PRELIMINARY/FINAL DRAINAGE REPORT

JUDGE ORR ROAD RV PARK & STORAGE DEVELOPMENT

**ADP Project No.160301
November 6, 2018**

PCD Project #PPR-16-040

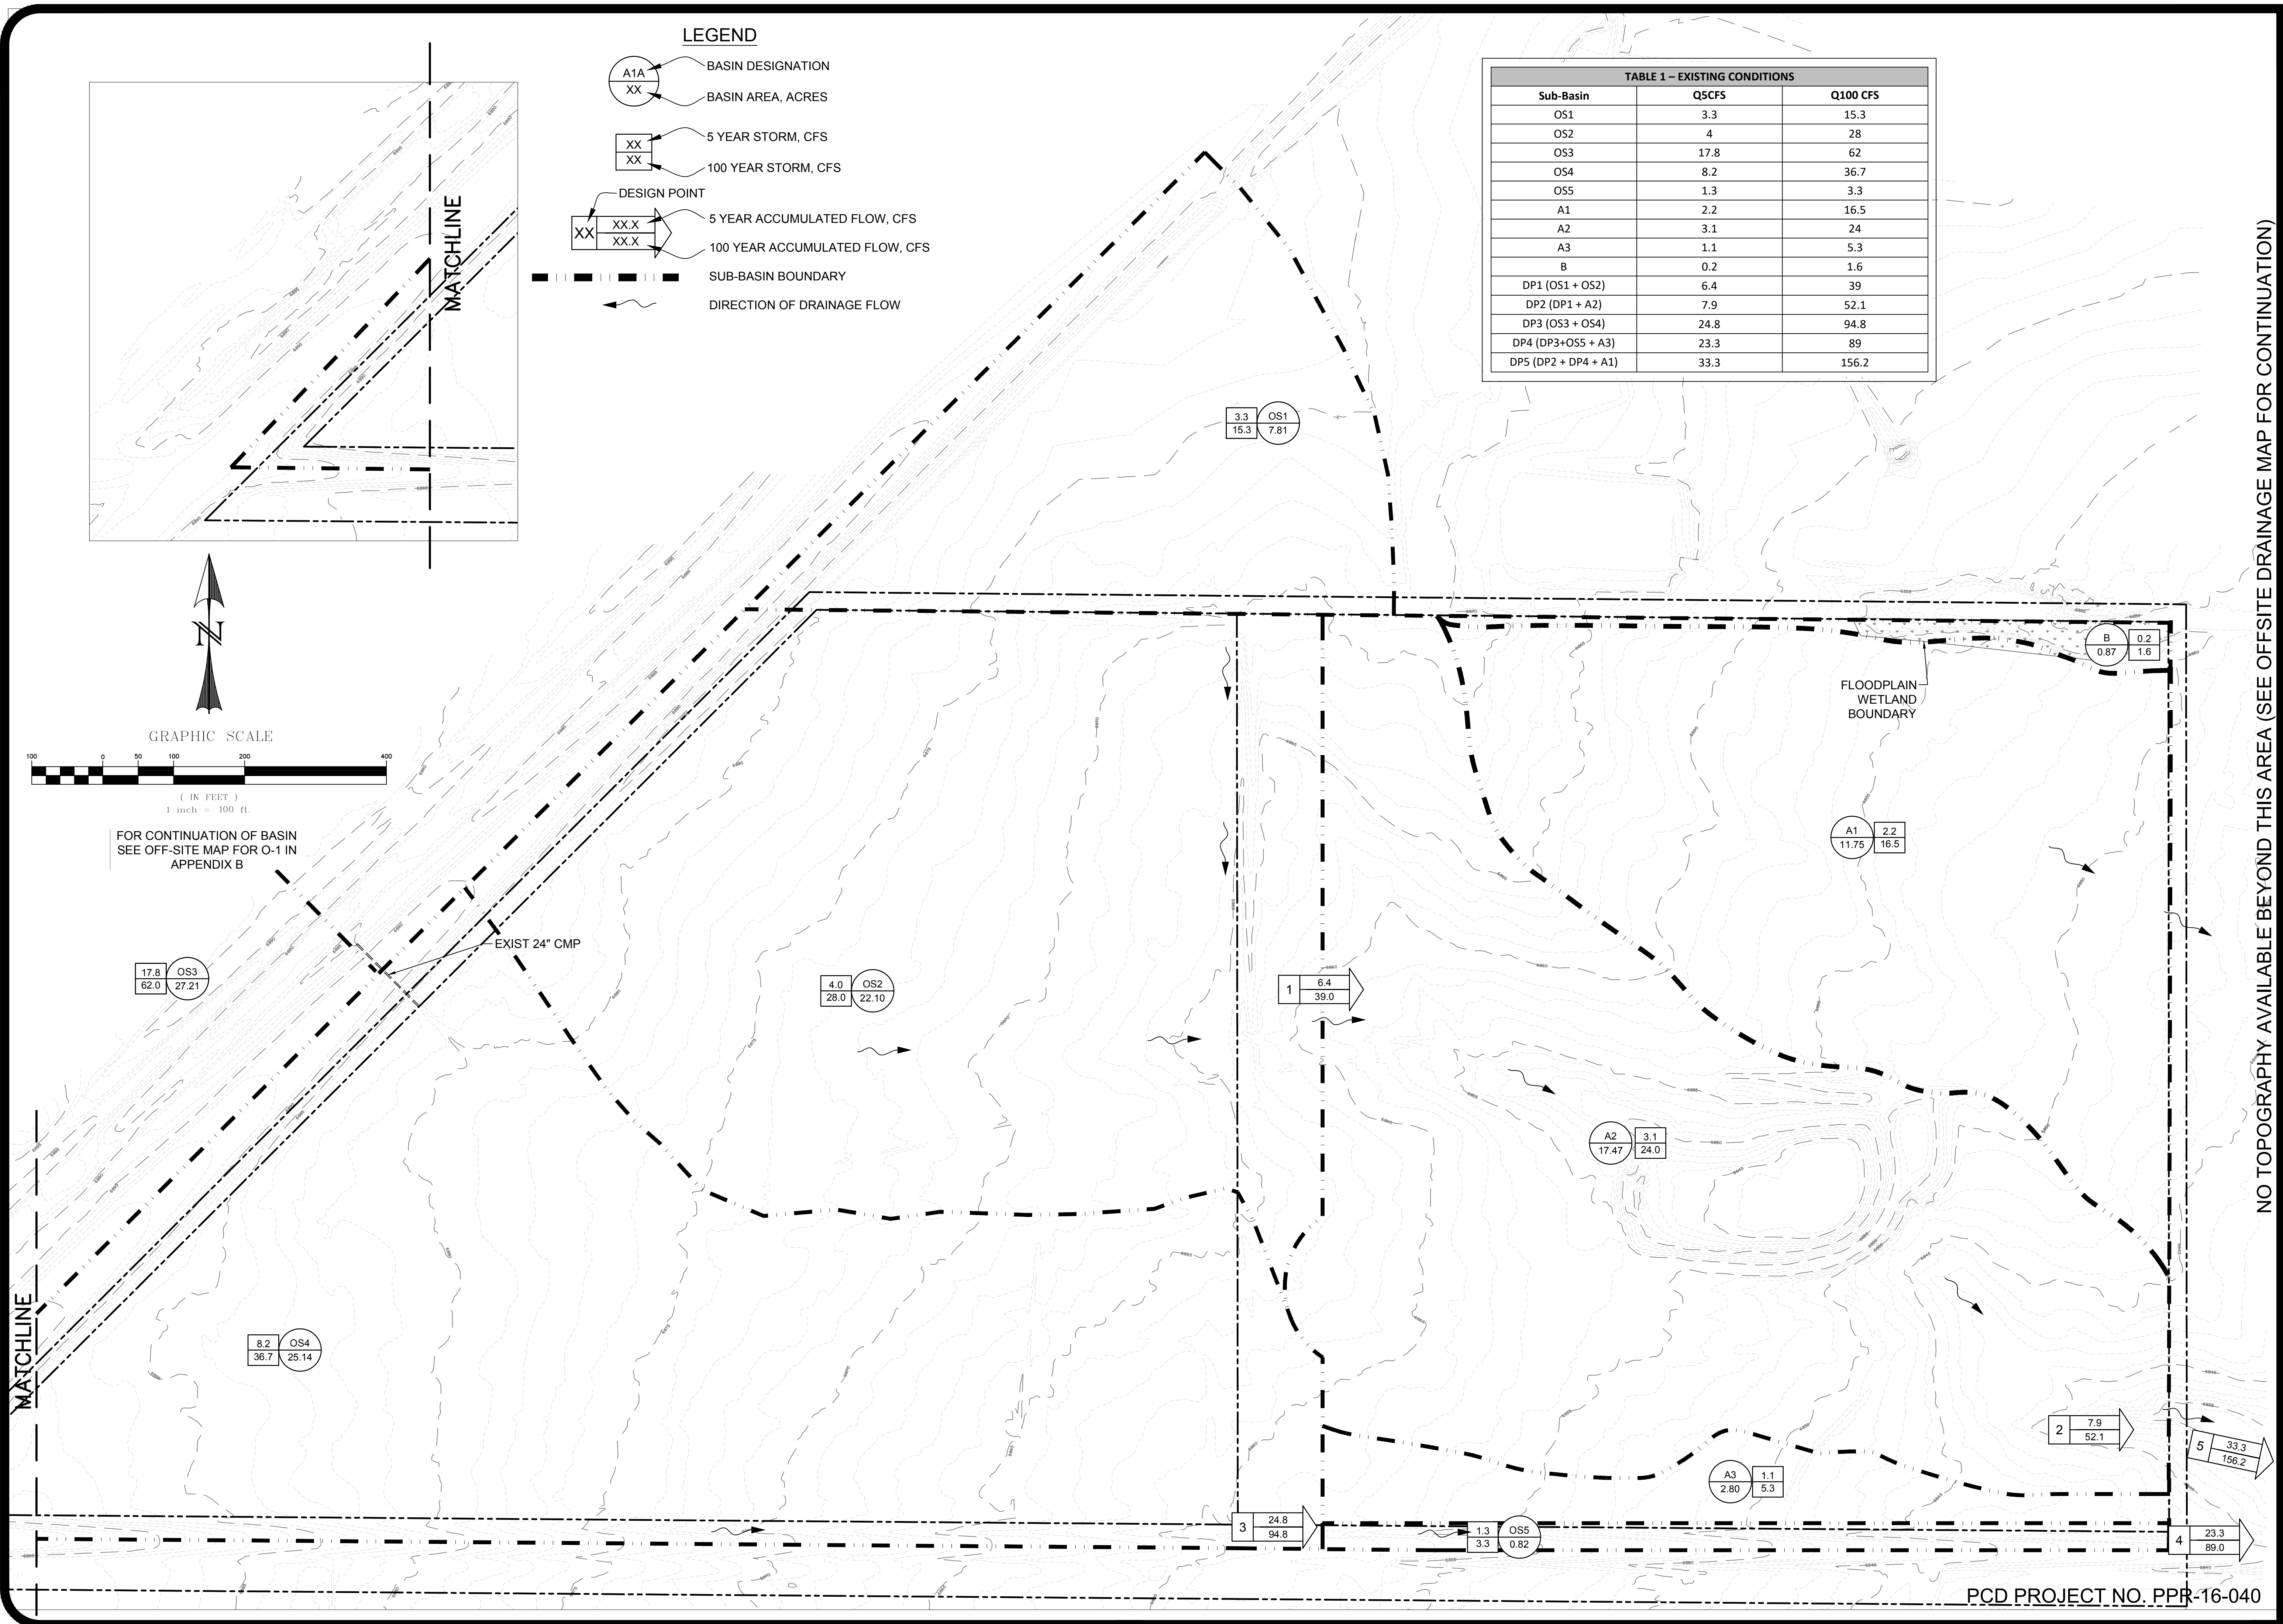
State in the narrative who own/maintain this stormline.

8/8/18 - Unresolved. This is to avoid confusion in the future since it is for conveying offsite flow across the property. When this property is platted, then this stormline must be located in a drainage easement.

12/4/18 Unresolved.

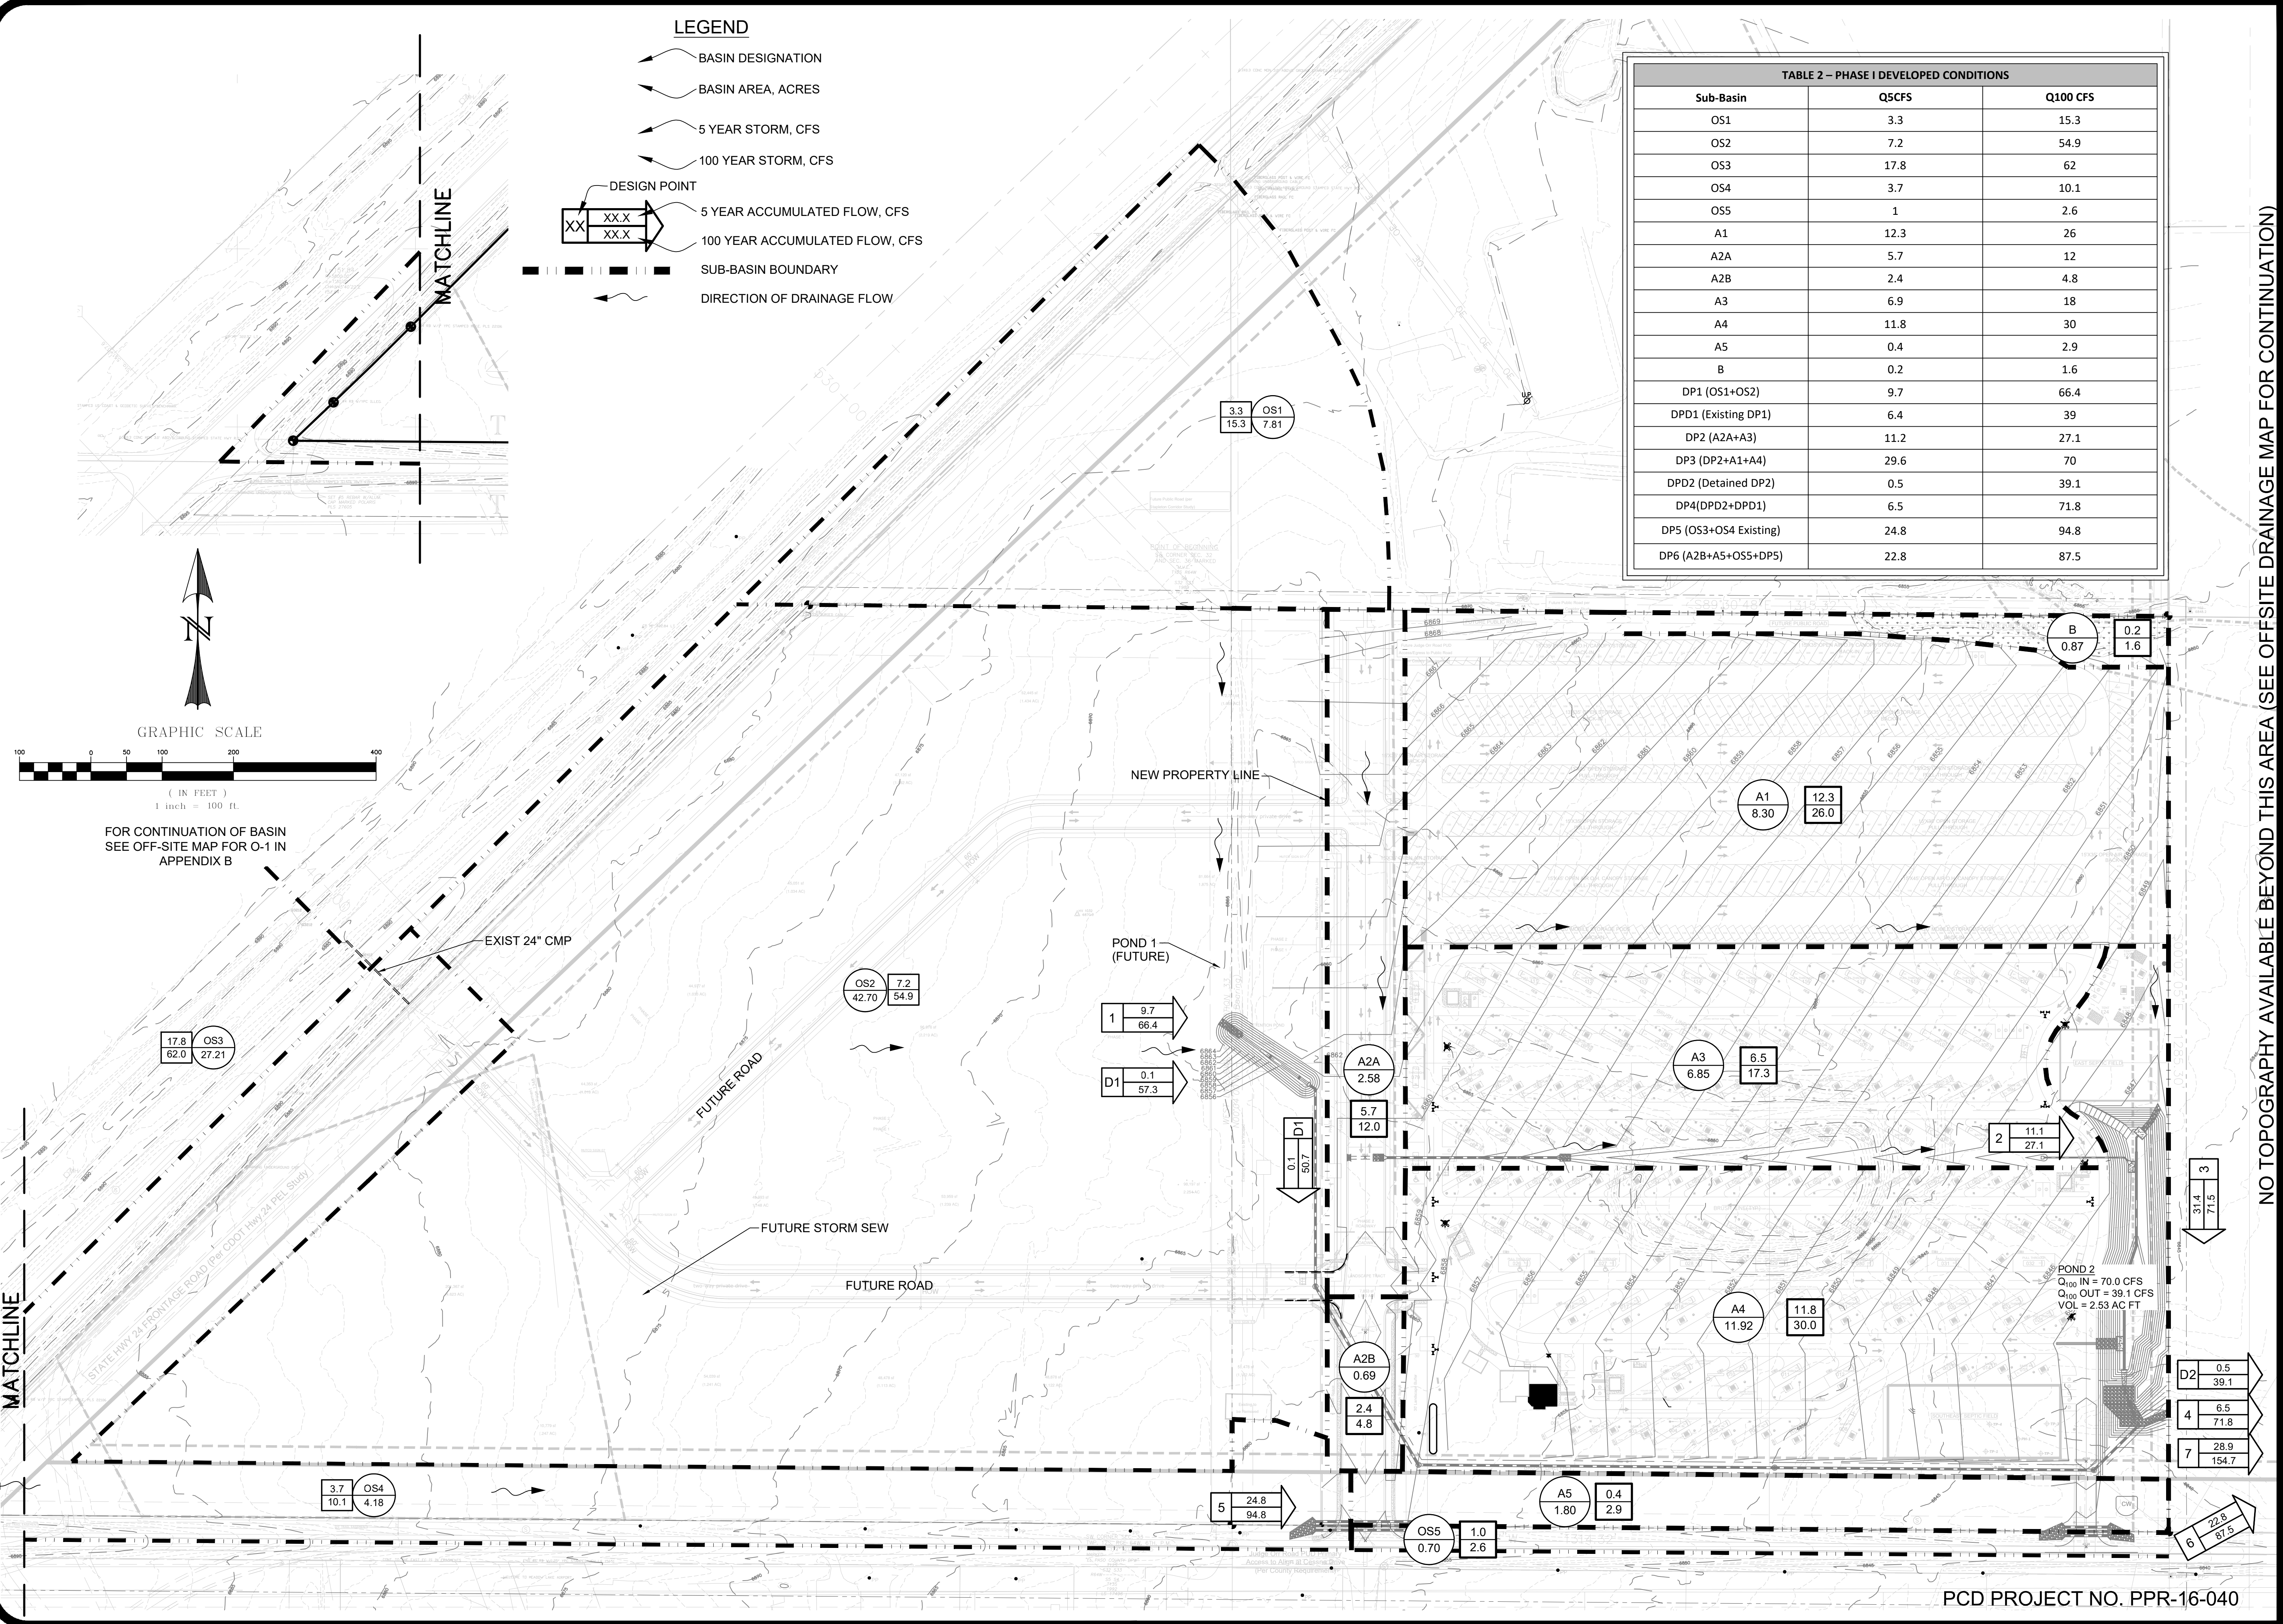
Categorically state whether the channel where D2 and DP 6 merge is hydraulically adequate or not.

Per DCM 6.5.2, grass lined channel shall not be used where the Froude number is greater than 0.9. Unresolved. See comment in the proposed drainage map for additional detail.

100yr depth exceeds the swale design depth

Swale F & G is missing
